**Re: Kendall Auto Group Service Center – PA23-024
16100 Smokey Point Boulevard
ZGA Project Number: 2310.00**

Subject: Responses To Land Use Technical Review Comments

A101
 SITE PLAN

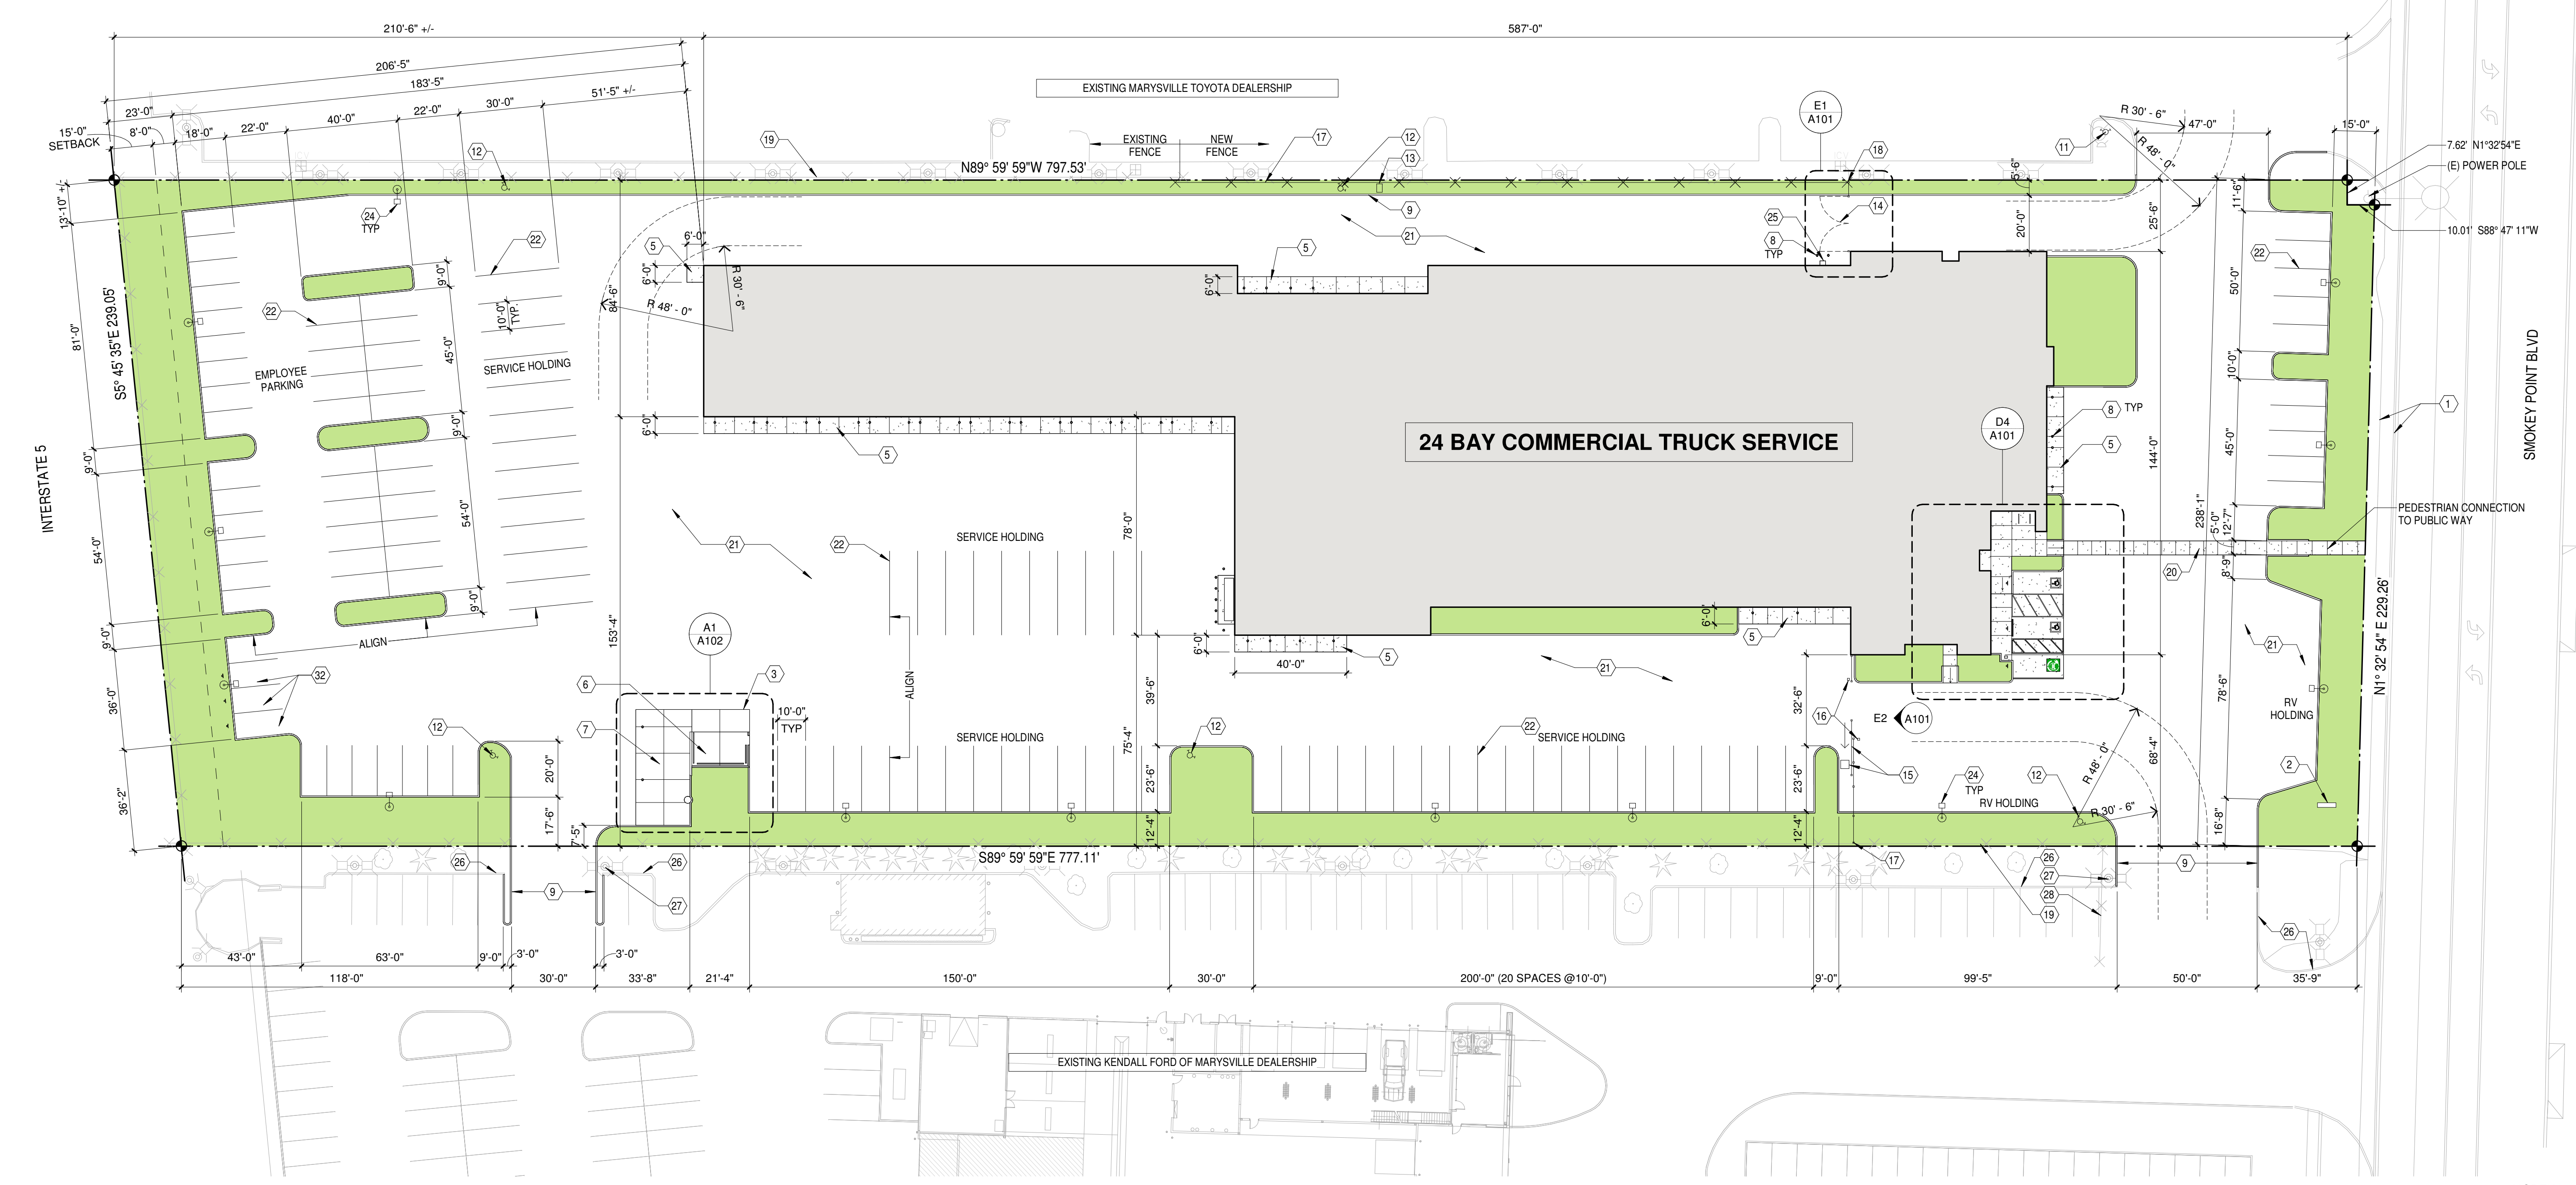
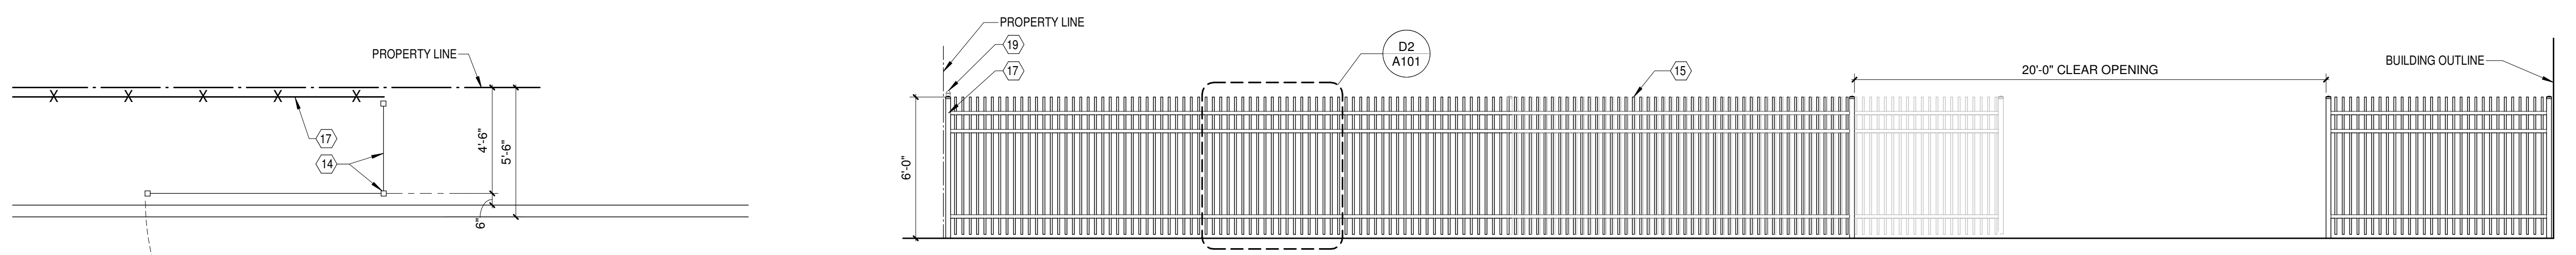
5. The calculations for determining the minimum number of parking spaces has been included in the Site and Building Data on drawing A101, Site Plan.
6. The calculations for determining the minimum bicycle parking is included in the Site and Building Data on drawing A101, Site Plan. Three bicycle parking spaces required; two bicycle racks accommodating two bicycles each are indicated by keynote 4.
